From: Richard Castro-Parker
Sent: 21 August 2019 11:48
To: Samantha Lee
Cc: Daniel Vick; Laura Gibbons
Subject: RE: BE/139/18/PL - Innovation Centre Beeding Close

Further to our telephone calls today, I had already asked the Laura Gibbons about the drainage matters you raised (see my email below). Laura has commented and has requested the following:

- Proposed Drainage Layout – 1:100 Scale;
- Proposed Drainage Layout – 1:400 Scale.

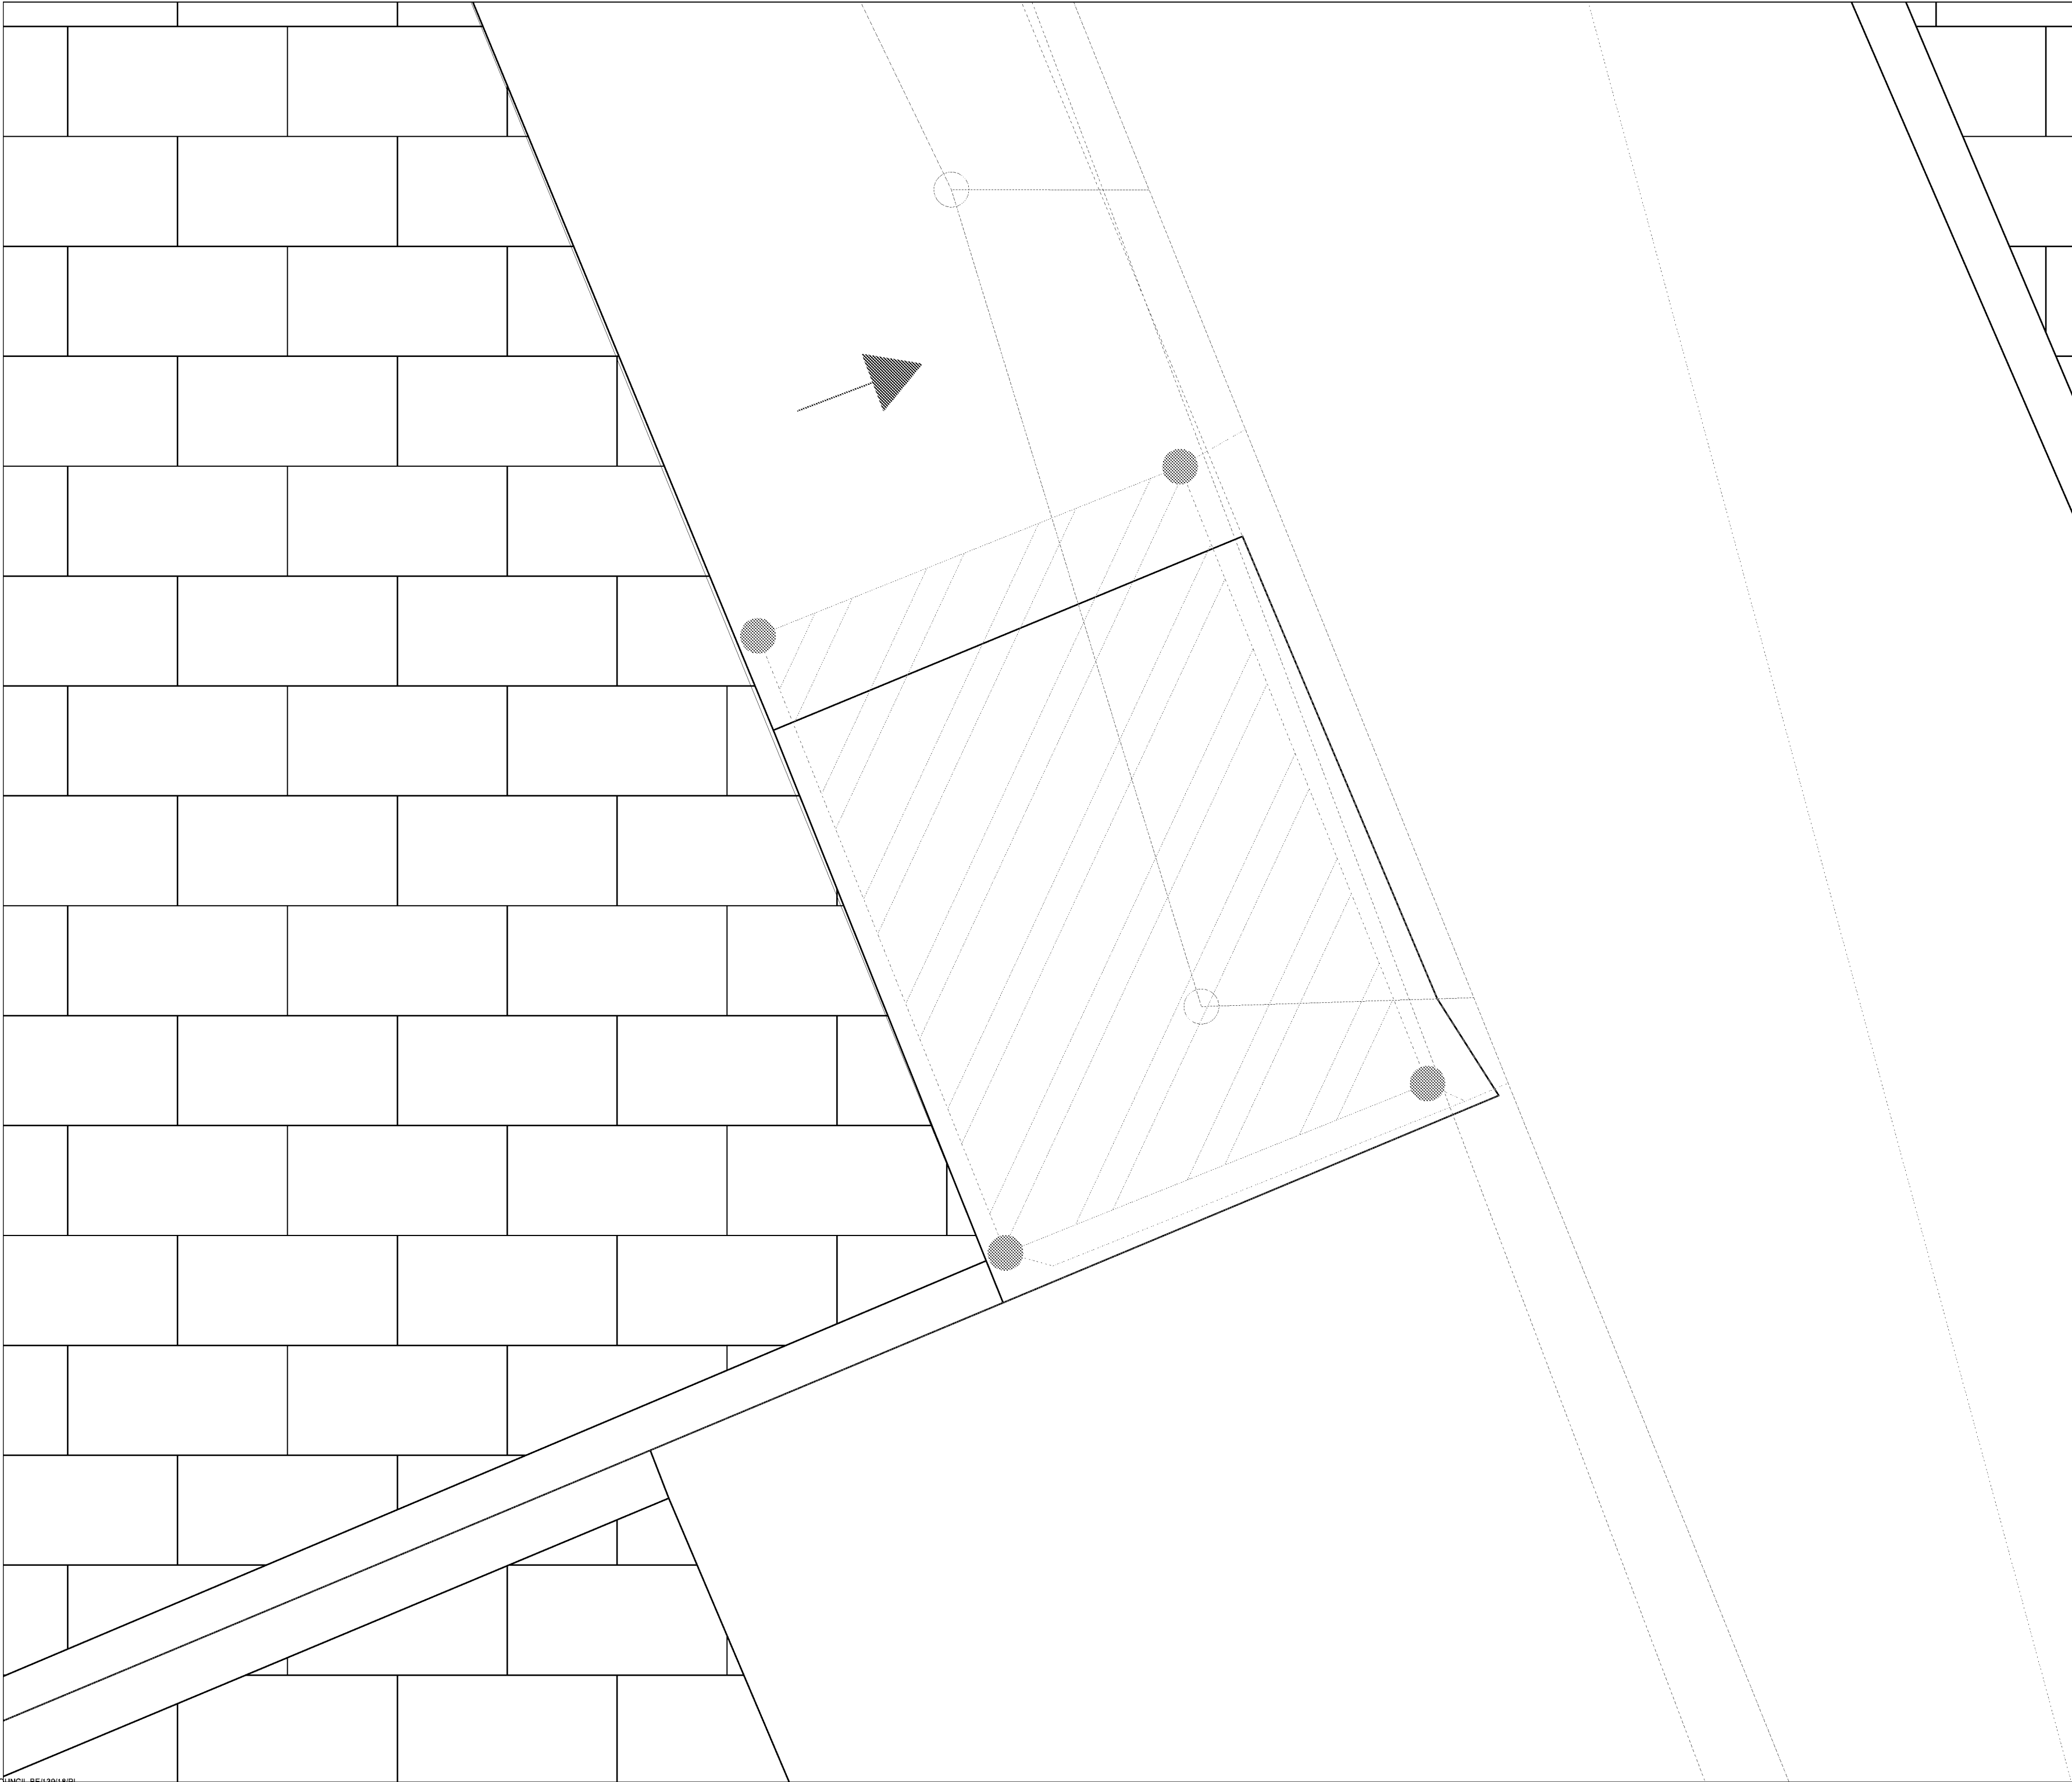
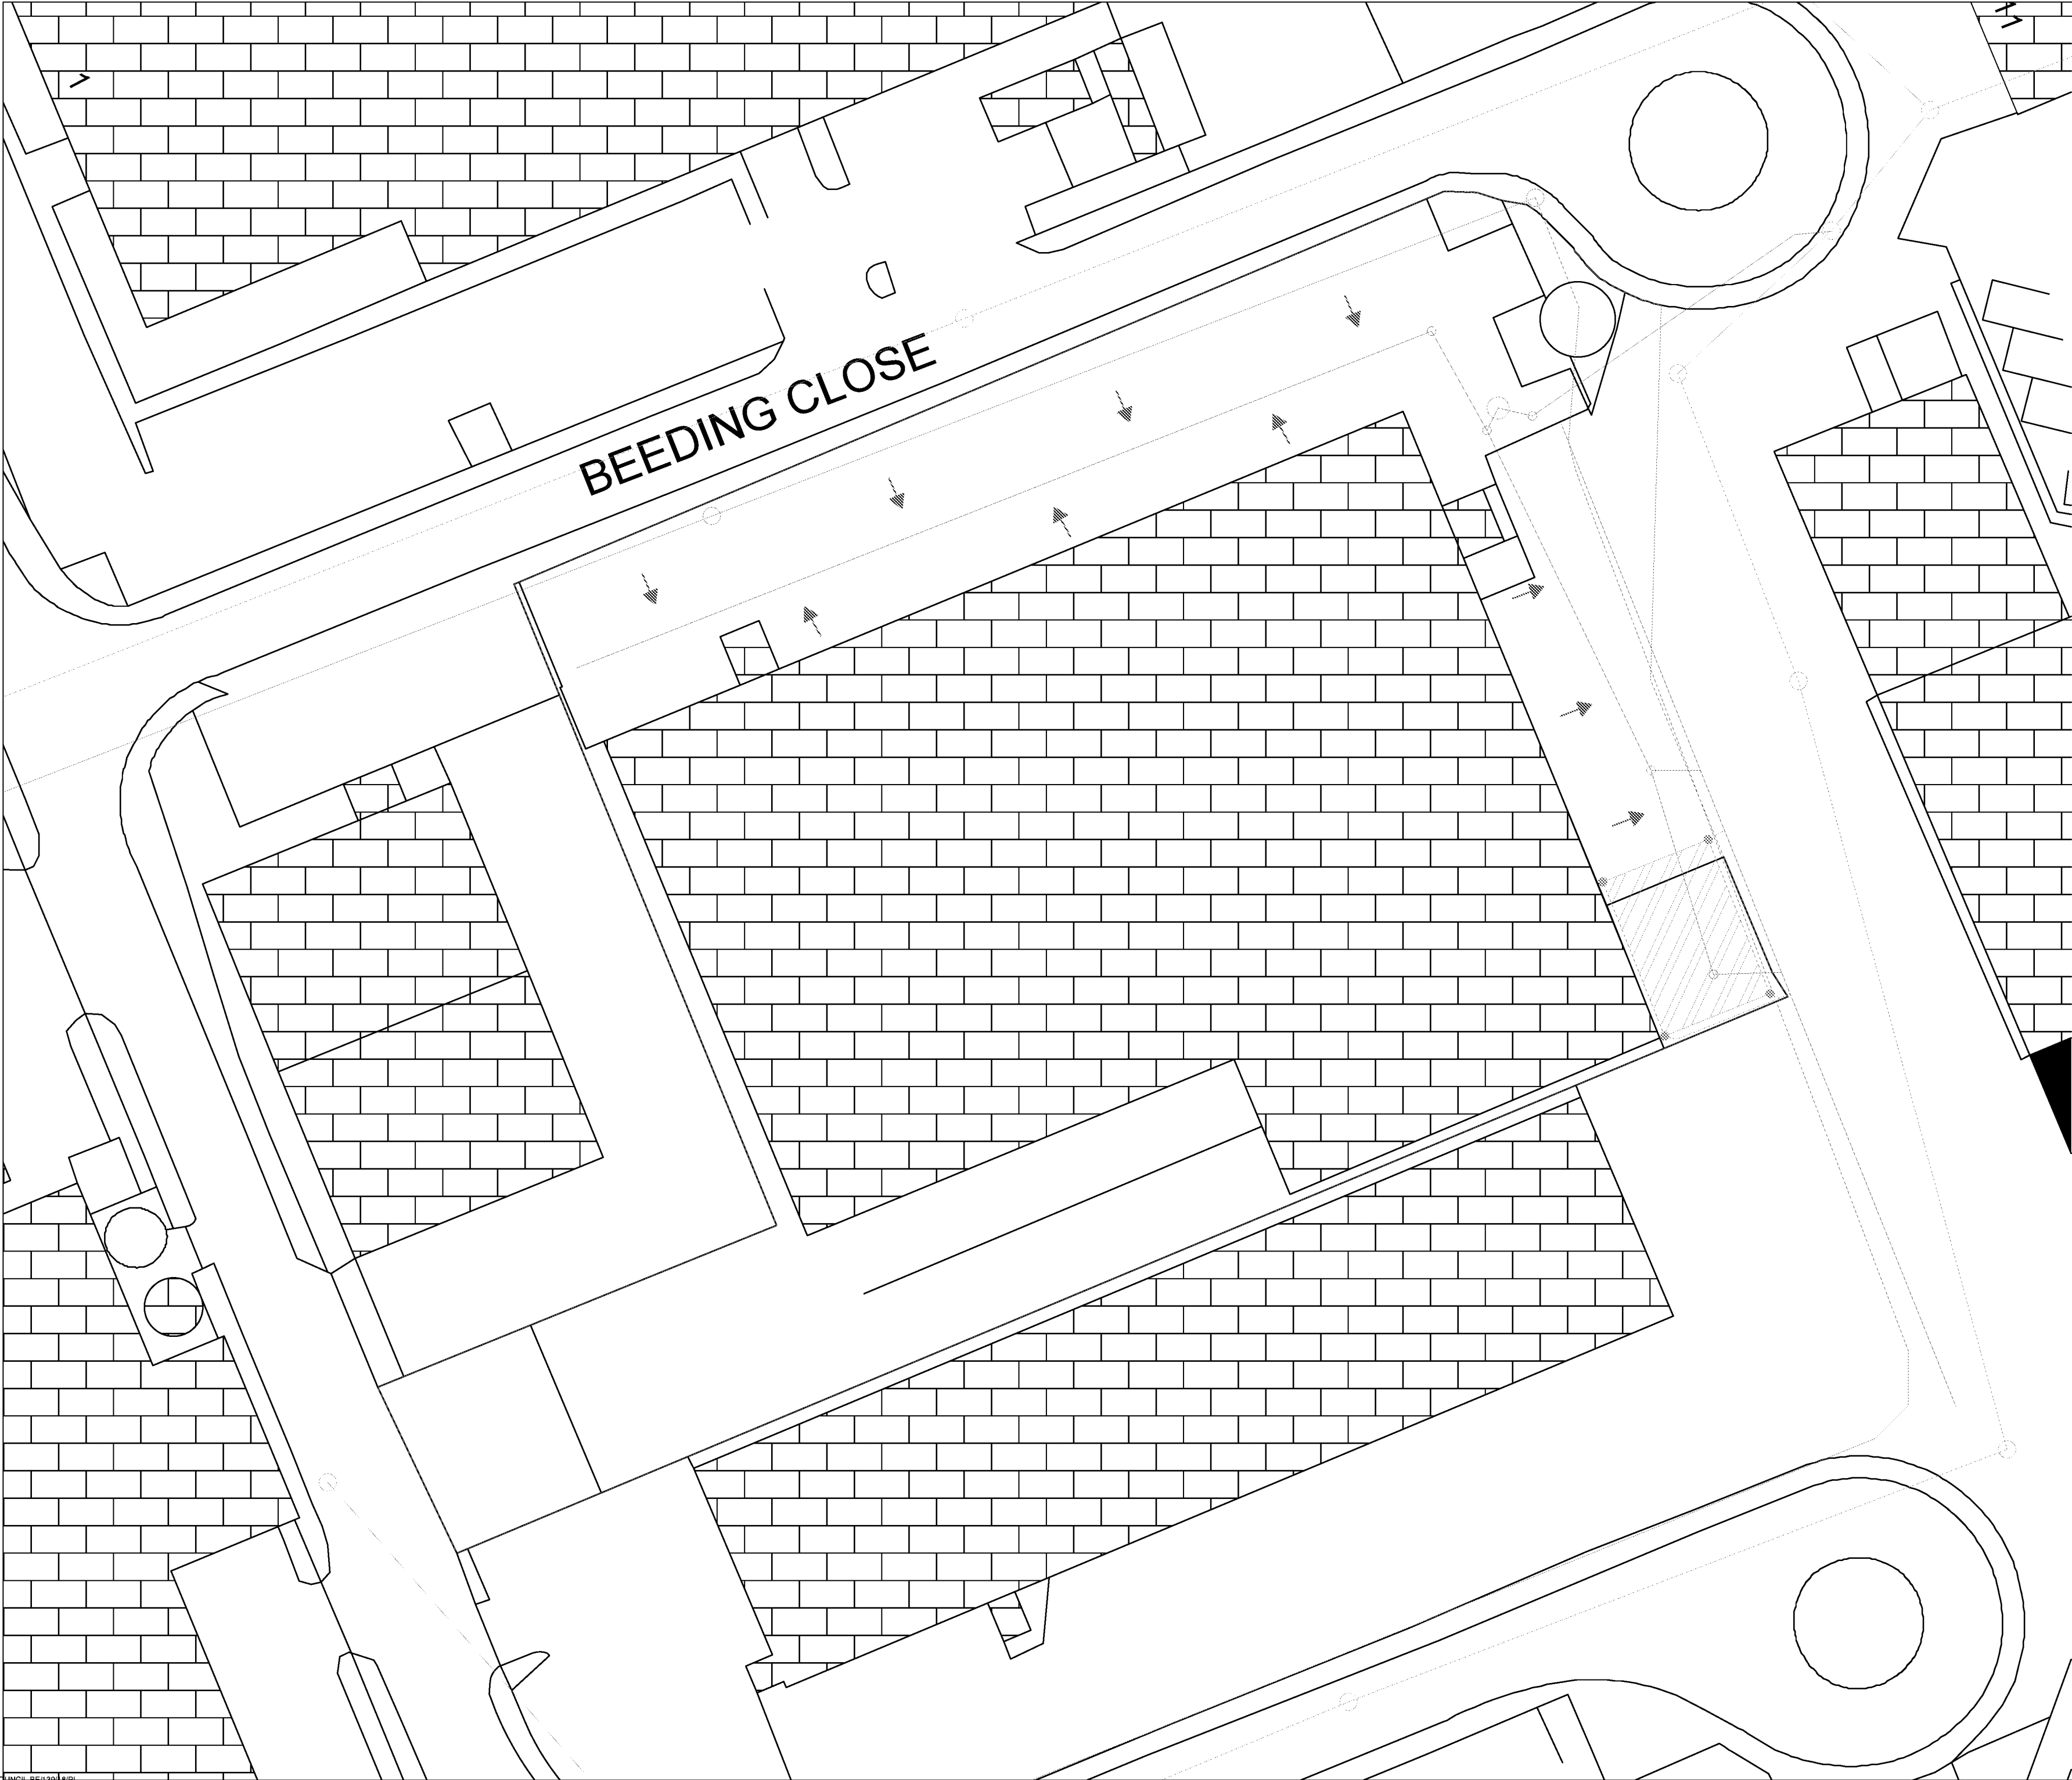
Please can the applicant submit clearer plans of the proposed surface water drainage arrangement. I.e. different line types used, rather than all very similar colours. Please can gullies, manholes, and linear drainage channels be clearly labelled.

I also require levels to be submitted showing invert and cover levels of the existing drainage network and spot levels of the surrounding land. This is fundamental to ensure that the surface water from the development does not go off site.

Please find attached a PDF of the drainage layout plan for the site. Given the size of the site, all lines on the plans are small. However, if Laura zooms in she will be able to distinguish between the pipes types. This should hopefully address her first concern.

With regards to levels, having reviewed the sewer asset location search requested from Southern Water, both invert and cover levels for all Southern Water manholes are detailed within their response. A copy of the sewer asset location search was included within the appendix of the Surface Water Drainage Strategy – this have been attached to this email for her reference.
